A46 Newark Bypass

Scheme Number: TR010065

Statement of Common Ground with Nottinghamshire County Council

December 2024

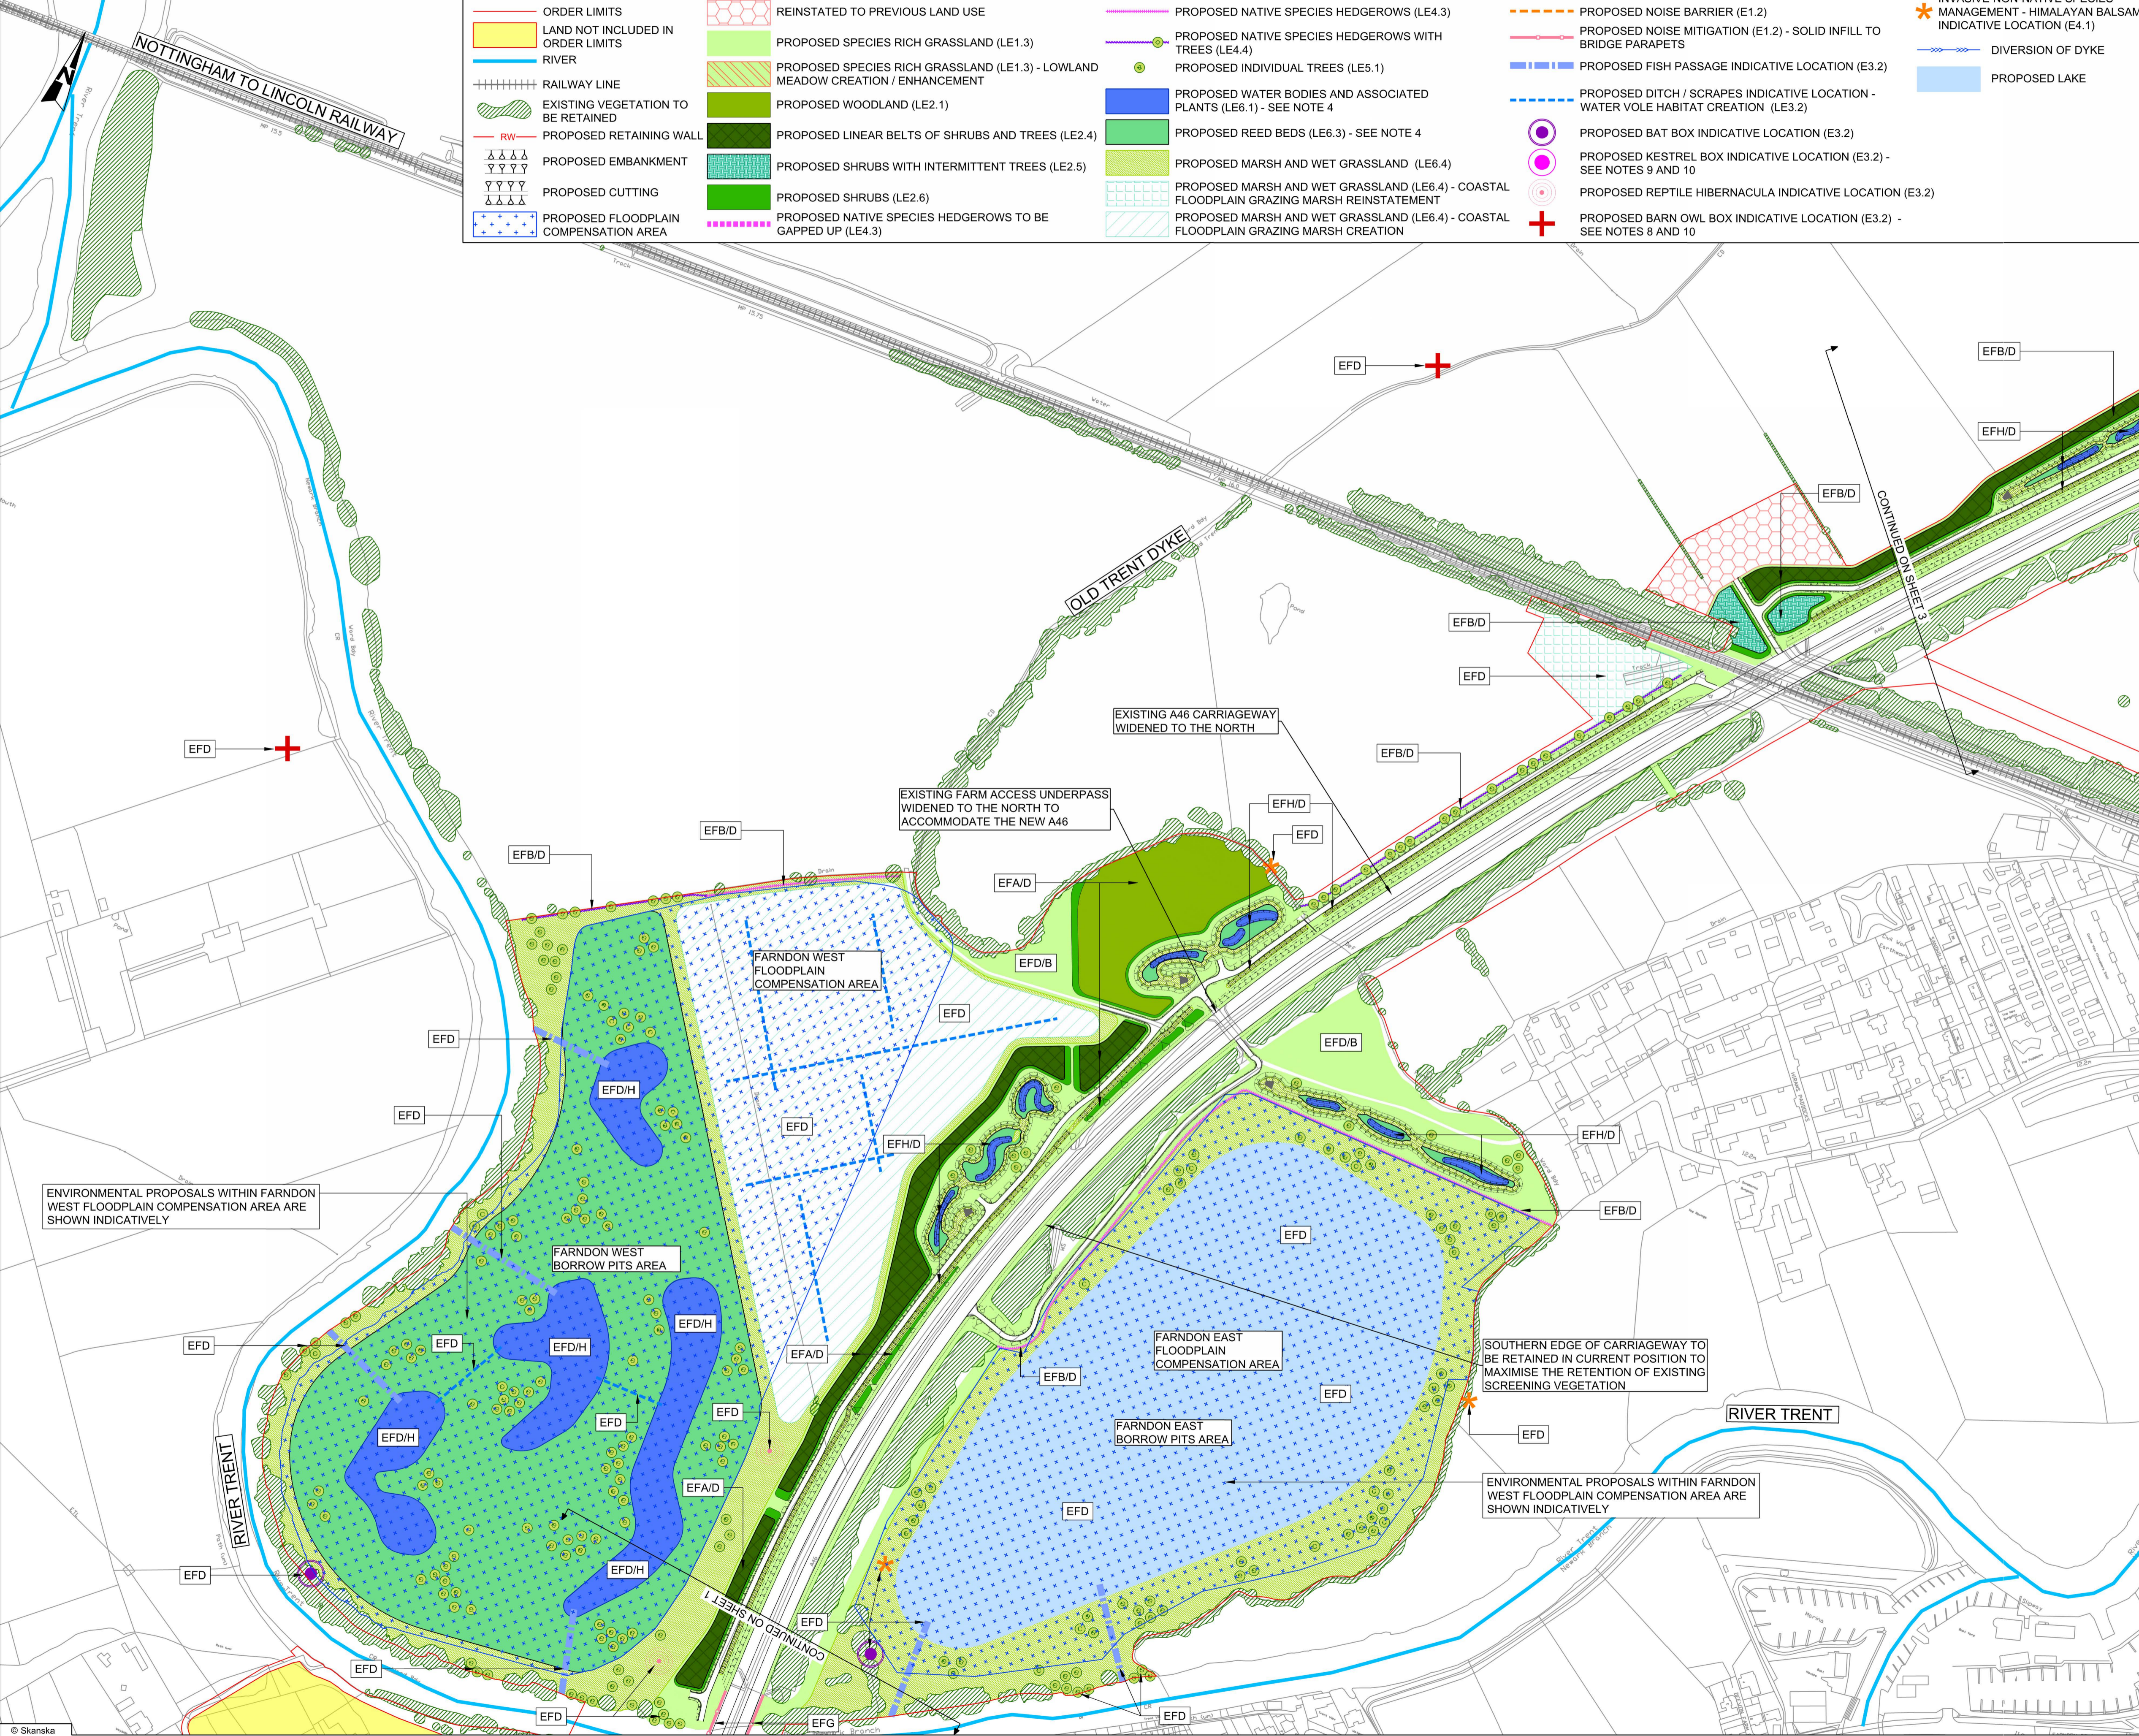
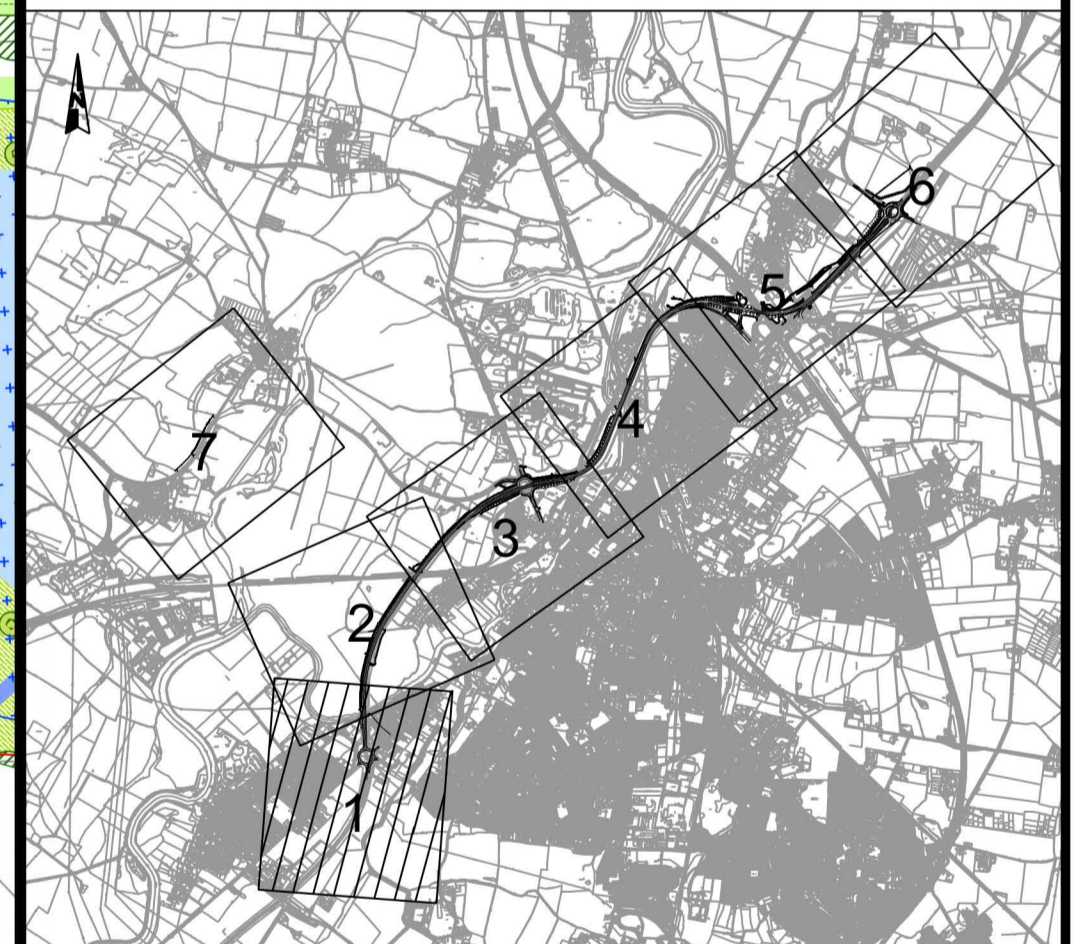
5.	PRoW		Farndon A46 roundabout The plans indicate that the Farndon Underpass will remain open throughout the works which is good. As you are aware the land adjacent to Crees Lane is currently used by members of the public as a walking route, we are also aware that National Highways are planning to use this as a compound. We would support the opportunity to create a public footpath at this location to link the underpass with Footpath No.5 and Bridleway No.2. Farndon A46 roundabout - the land which is set out for the works compound adjacent to Crees Lane has a number of unrecorded desire lines through it. It would be advantageous to see these formally recorded and set out following completion of the Scheme.	Following feedback received as part of the statutory consultation, the temporary diversion of bridleway BW2 was changed, and an alternative route was presented as part of the targeted consultation on the Scheme between 14 March and 16 April 2023. Following further feedback received as part of the targeted consultation the temporary diversion of the bridleway will be only for use by equestrians. Pedestrians and cyclists will utilise the existing footpath FP5 from the River Trent to gain access to the route adjacent to Crees Lane shown within the Order Limits. The unrecorded desire lines are on a piece of land that has been identified for temporary use as part of Scheme, any activity to formally record these desire lines as Public Rights of Way would need to be undertaken by stakeholders, including NCC, outside of the Scheme.	Agreed	04/11/2024
